SUBMISSION: 19-23 Rosalind Street, Cammeray.

Please accept this document as objection to the proposed SSD (SSD-96505456) based on the following criteria which will be discussed in further detail in this submission:

DRAWING TITLE  
 SHADOW DIAGRAMS 1/2  
 DRAWING NUMBER  
 DA-400  
 REVISION  
 A

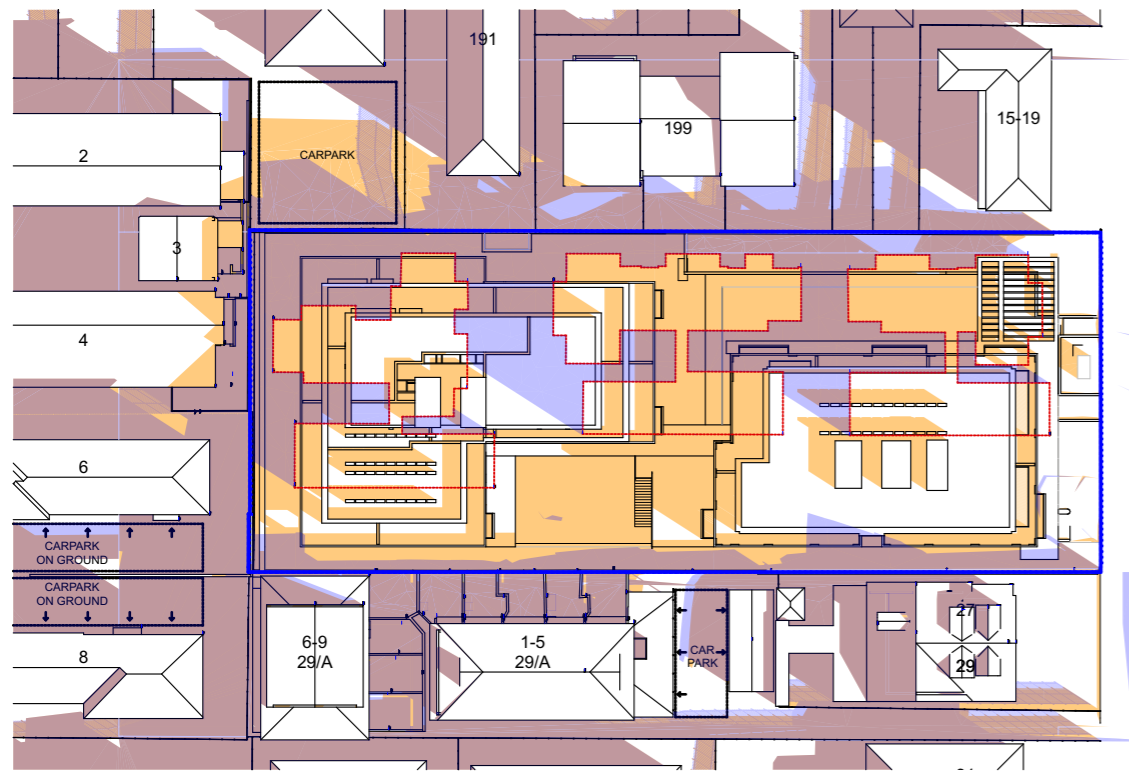
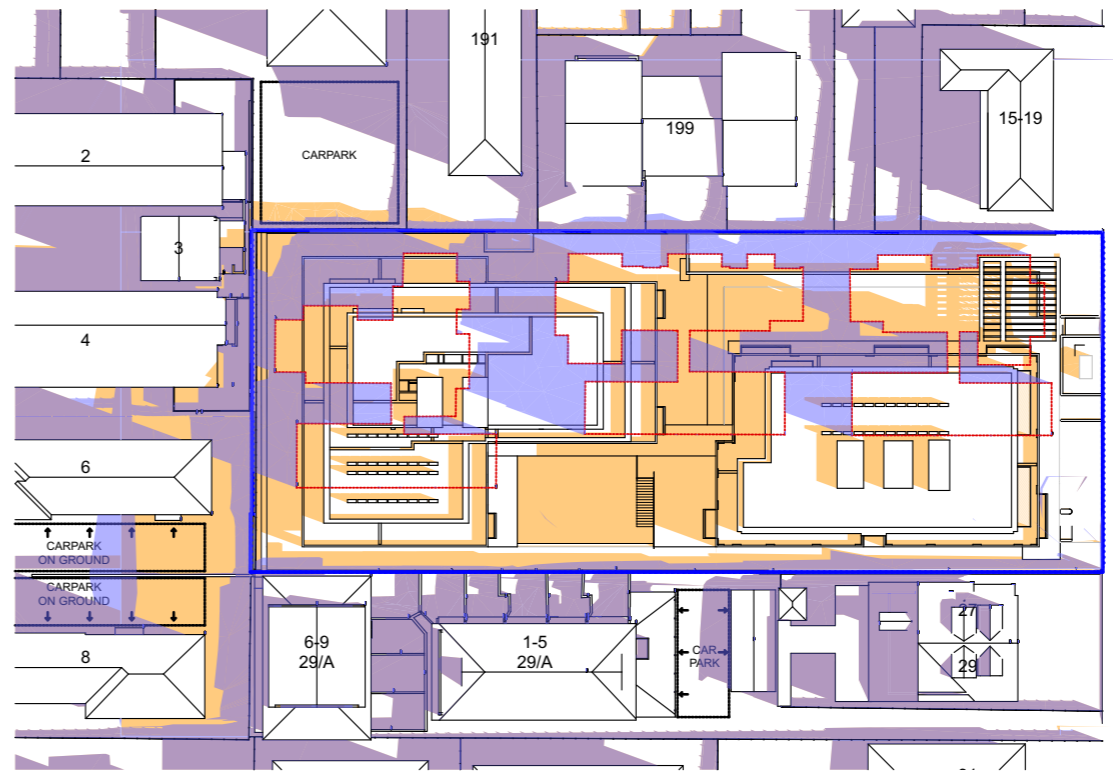
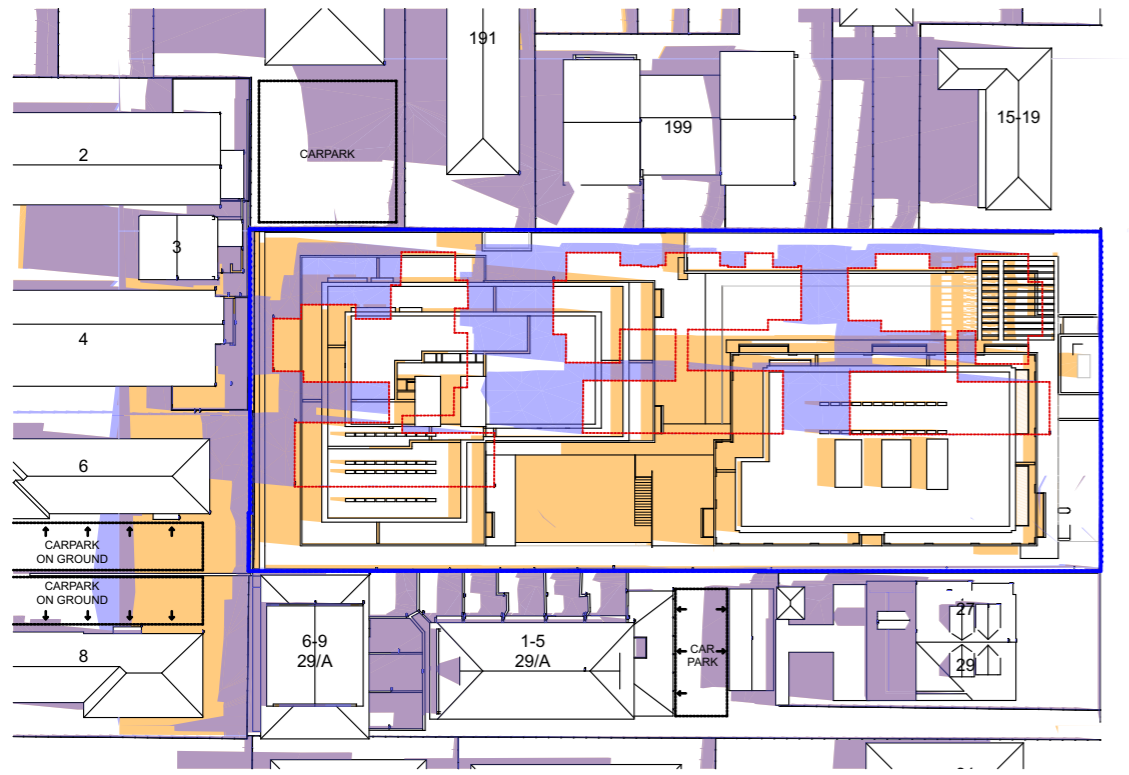
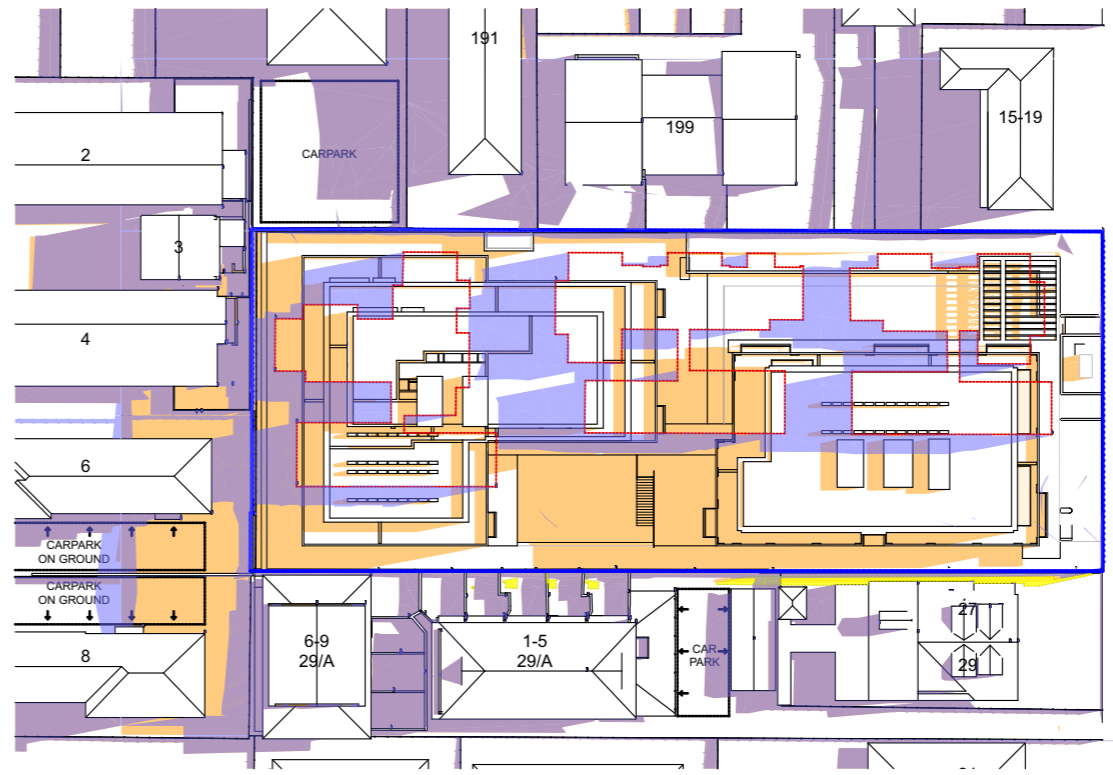
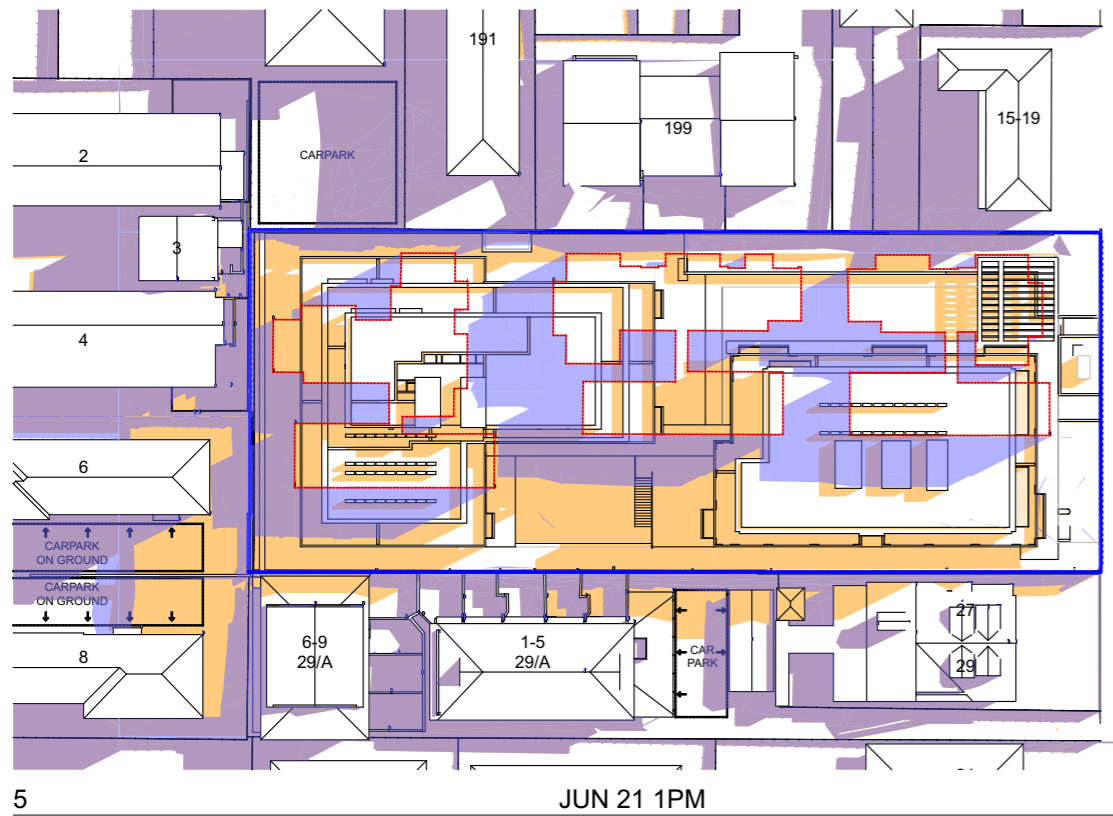
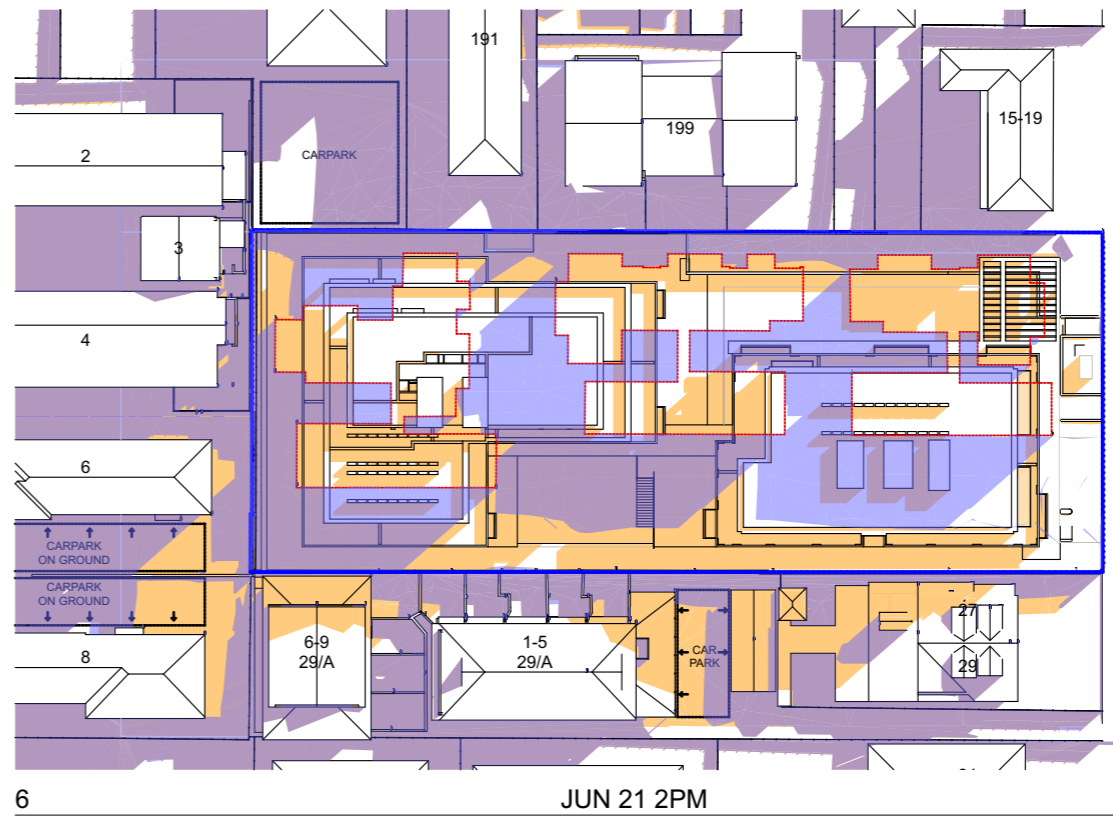
Section 6.1.4 Overshadowing of the EIS has failed to address this issue of overshadowing to adjoining and nearby properties which will have an impact on solar, especially with the affected residents on 199 West Street. Each townhouse has two skylights each which will be affected by overshadowing. The SSD admits that there will be an impact on solar and overshadowing, but no solution has been sought.

The Shadow diagrams in Appendix A Architectural Drawings.PDF do not adequately illustrate the impact of overshadowing on neighbouring properties.

- Height for Building A and B should only be set to 15.8 metres
- Setback should be at least 12 metres from western side of property.
